RE: Winkels Short Plat (SP-07-144)

The Kittitas County Community Development Services Department is issuing a **revised conditional preliminary approval** for the Winkels Short Plat (SP-07-144) due to revised comments received from Kittitas County Department of Public Works on January 22, 2008. Kittitas County Community Development Services issued the original conditional preliminary approval on December 14, 2007. The Winkels Short Plat (SP-07-144) is subject to the following conditions:

MEMORANDUM

TO: Trudie Pettit, Staff Planner, Community Development Services
FROM: Randy Carbary, Planner II *RC*
DATE: January 3, 2008
SUBJECT: Winkels Short Plat

**WINKELS SHORT PLAT
PART OF SECTION 23, T. 17 N., R. 18 E., W.M.
KITTITAS COUNTY, WASHINGTON**

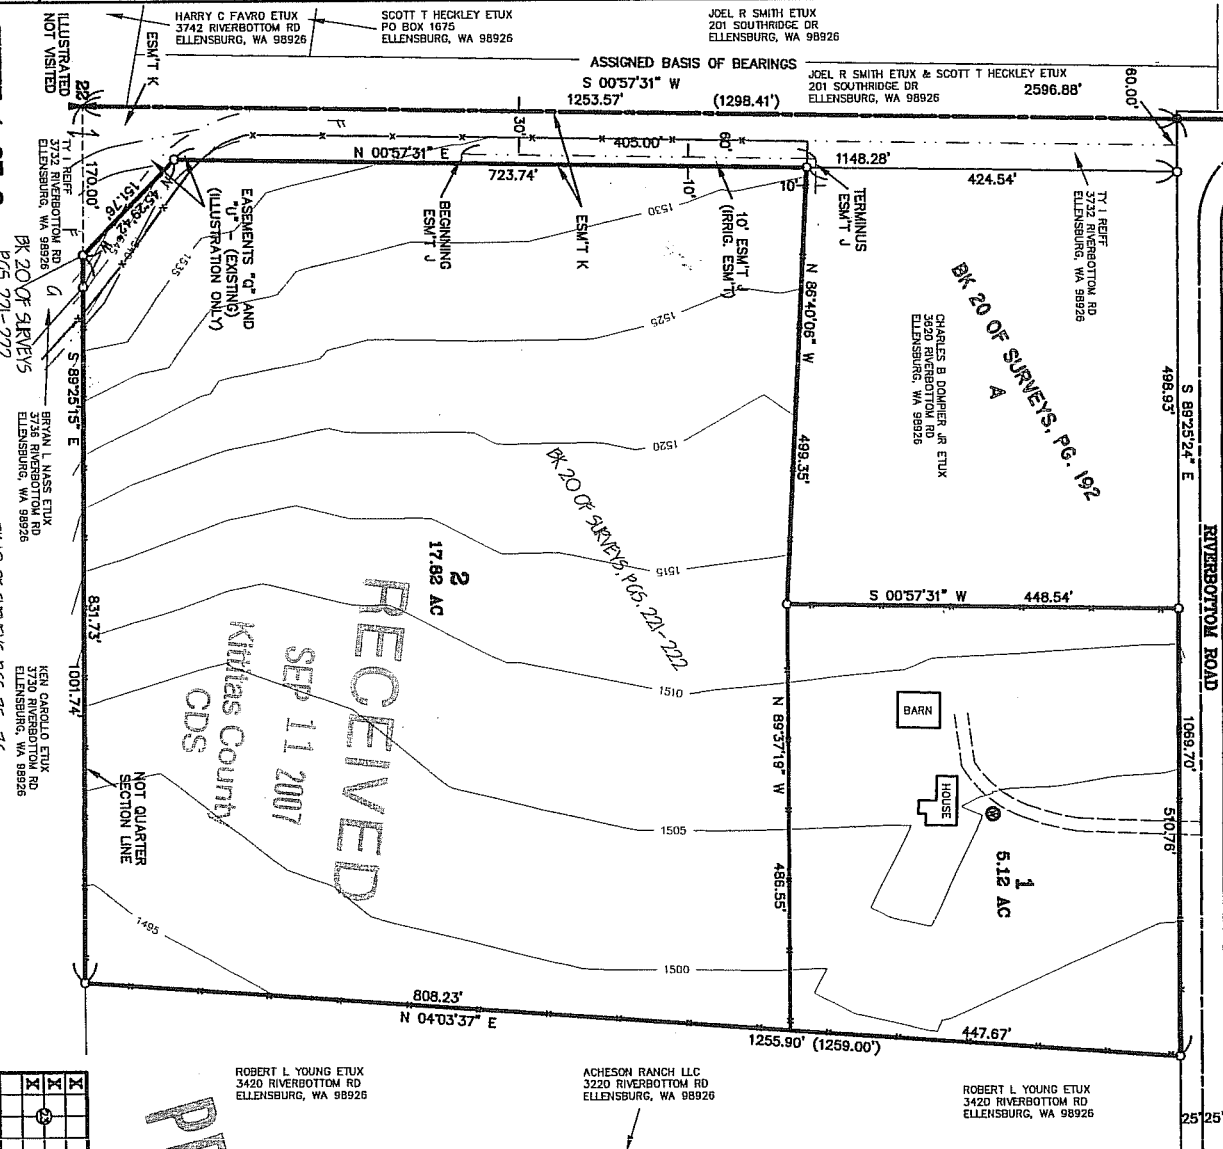
1. Both sheets of the final mylars shall reflect short plat number SP-07-144 and an accurate legal description shall be shown on the face of the final plat.

2. Private Road Improvements: Access to lot 2 shall be constructed as a Low-Density Private Road. Improvements shall be made from the intersection of Riverbottom Road, south, to the access for lot 2. See Kittitas County Road Standards, 9/6/05 edition.

3. Paved Apron Requirements: A portion of the intersection at Riverbottom Road is currently paved; however, there is still a triangular gravel area that exists near the intersection of Riverbottom Road and the private road that serves lot 2. A paved apron shall be required at this location. Contact our department for specific information.

- a. Access easements shall be a minimum of 60' wide. The roadway shall have a minimum width of 20', with 1' shoulders, for a total width of 22'.
 - b. Minimum centerline radius will be 60'.

- c. The surface requirement is for a minimum gravel surface depth of 6".
 - d. Maximum grade is 12%.
 - e. Stopping site distance, reference AASHTO.
 - f. Entering site distance, reference AASHTO.
